Capisic Pond Enhancement

Final Level III Site Plan

Project #: 2013-268 CBL 192-C001001

Prepared by: Jean Fraser, Planner  
Date: March 21<sup>st</sup>, 2014

**G-001**

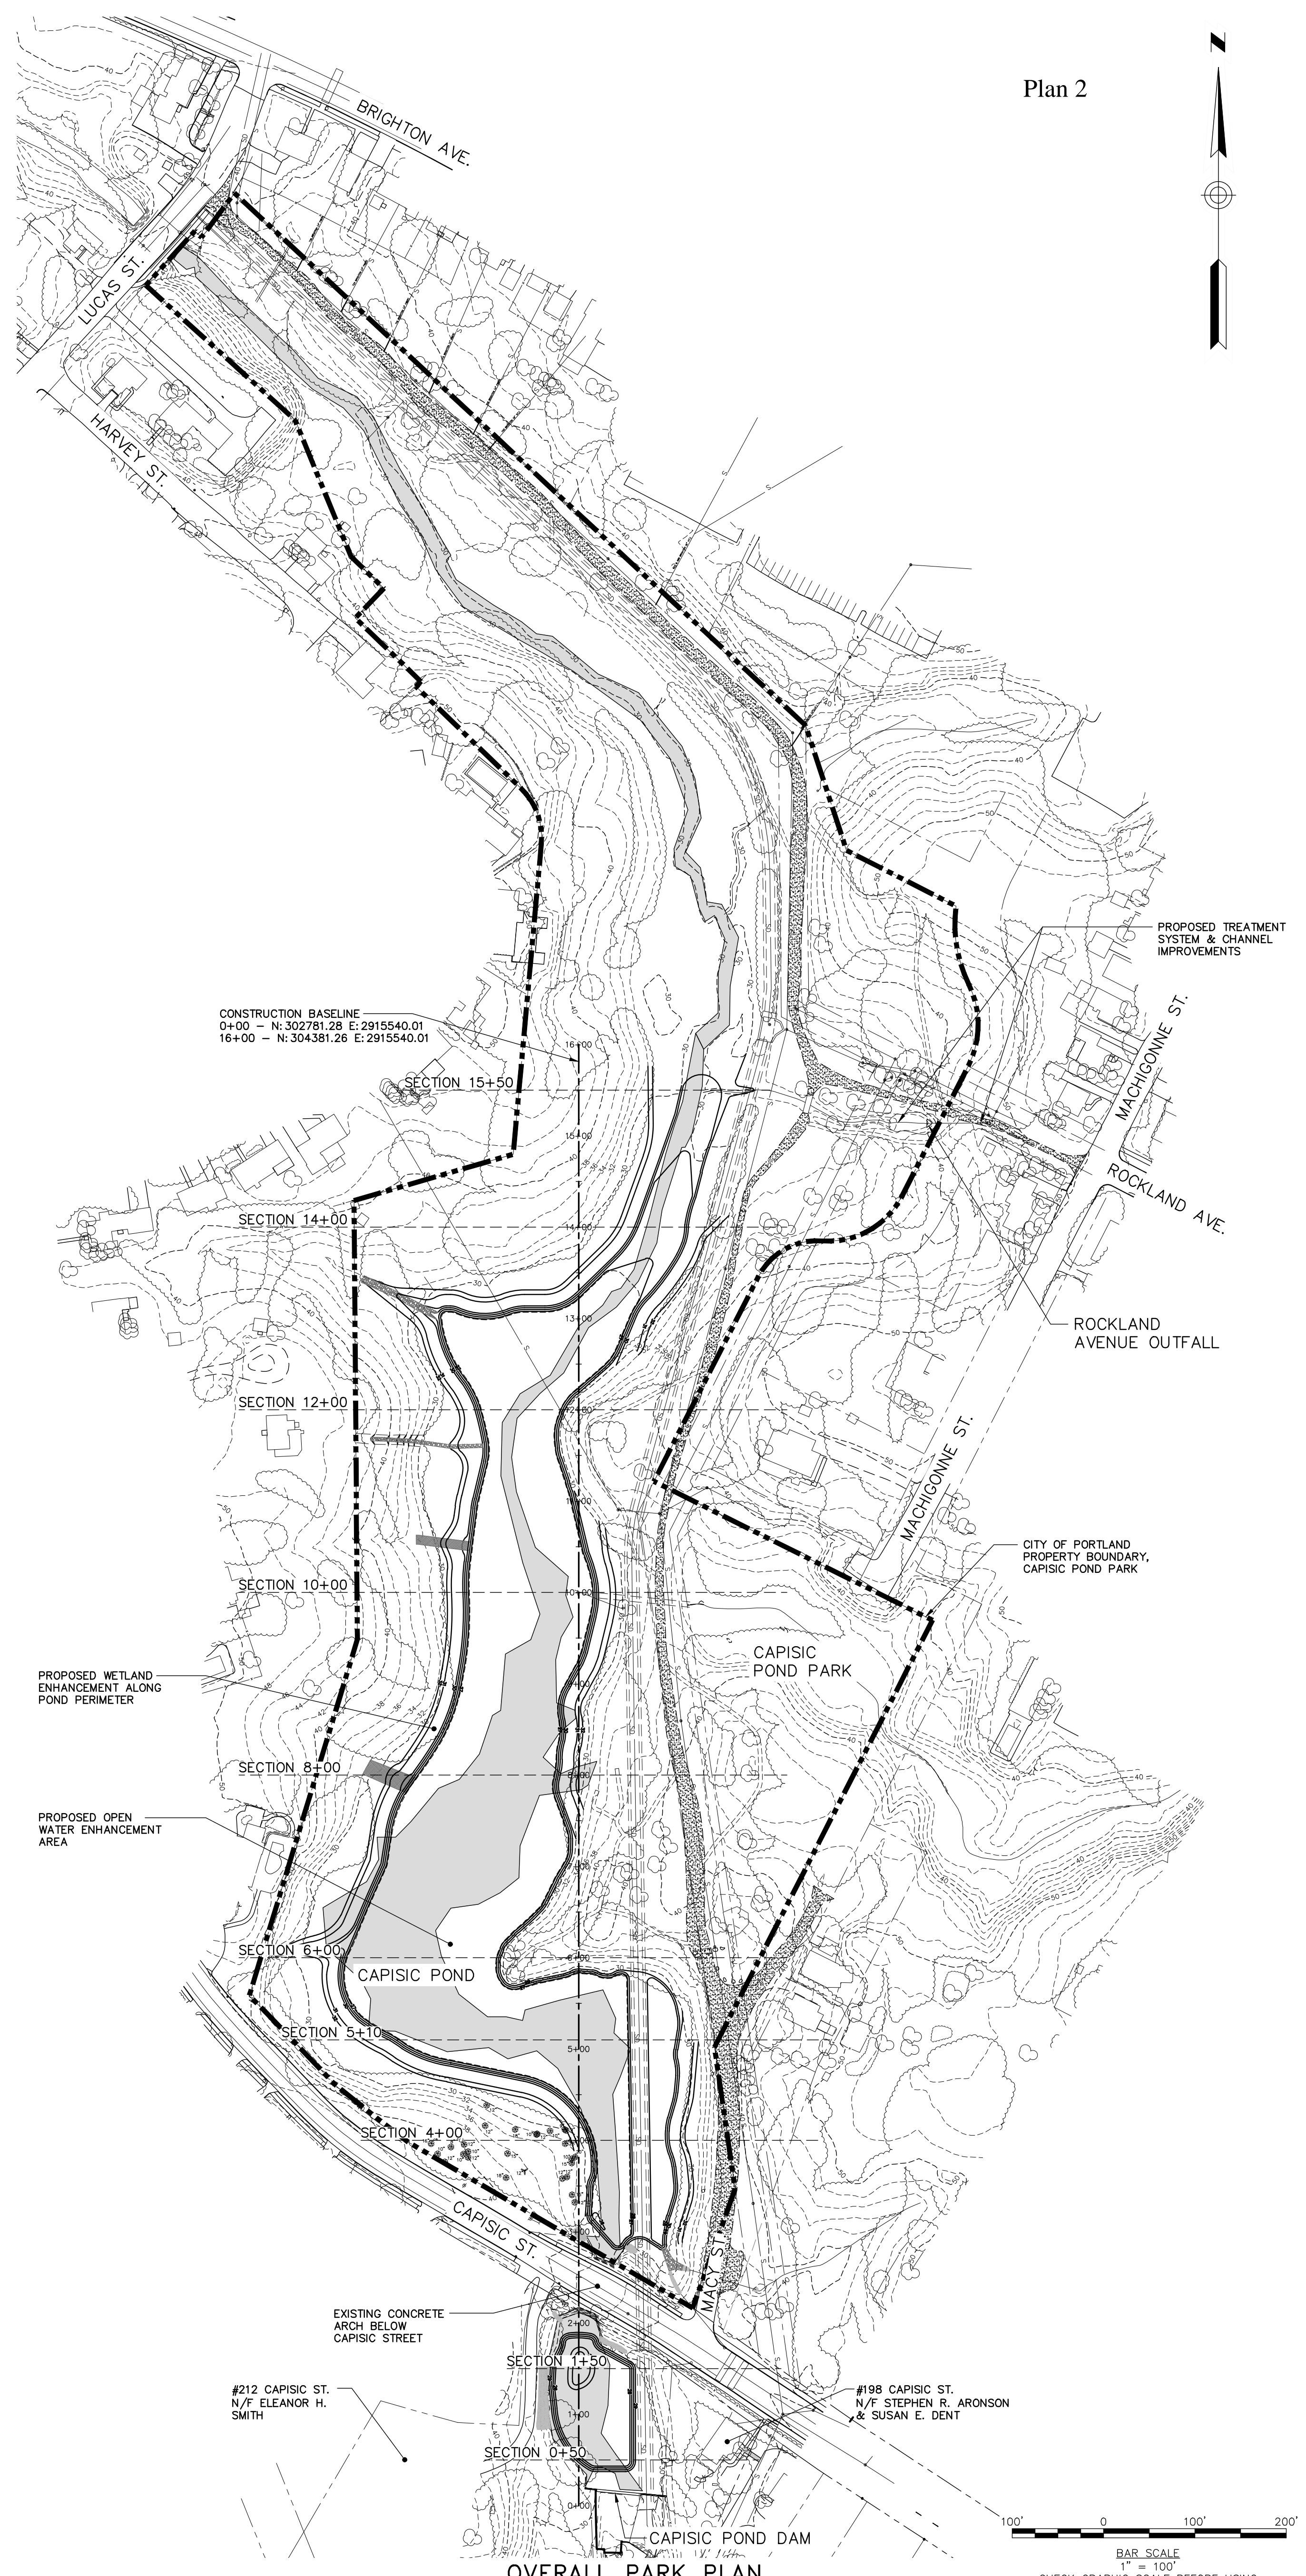
The written Construction Management Plan in Attachment K explains this aspect of the project in detail, and revised Plan P2, Notes 30, 31 and 32 clarify truck traffic routes and requirements for sweeping of the ROW. The issue of truck routes is a concern because the preferred route goes by the main drop off and pick up location for Breakwater School (grades pre-school to 8<sup>th</sup>) and Tom Errico has commented (Attachment 3):

*A proposed truck routing plan shall be documented. It is my understanding that it is likely that trucks will be destined to the City of Westbrook via Brighton Avenue. Accordingly, it seems reasonable that the routing consist of travel along Capisic Street to Brighton Avenue. I would suggest that truck activity avoid peak drop-off and pick-up times at Breakwater School. Also, provisions to ensure that vehicles are cleaned prior to entering the public street system should be included.*

The Plan (Note 30 on Plans P2. and P4.) has been revised to address the previous DPS comments (Attachment 4) that requested that the contractor be responsible for any sweeping due to materials inadvertently falling on the roadway between the dredge and disposal site. Comments from the Department of Public Services were not received in time to be included in this report and will be circulated at the PB meeting.

***Status: The applicant has provided a routing program that I find acceptable. This should be considered a condition of approval.***
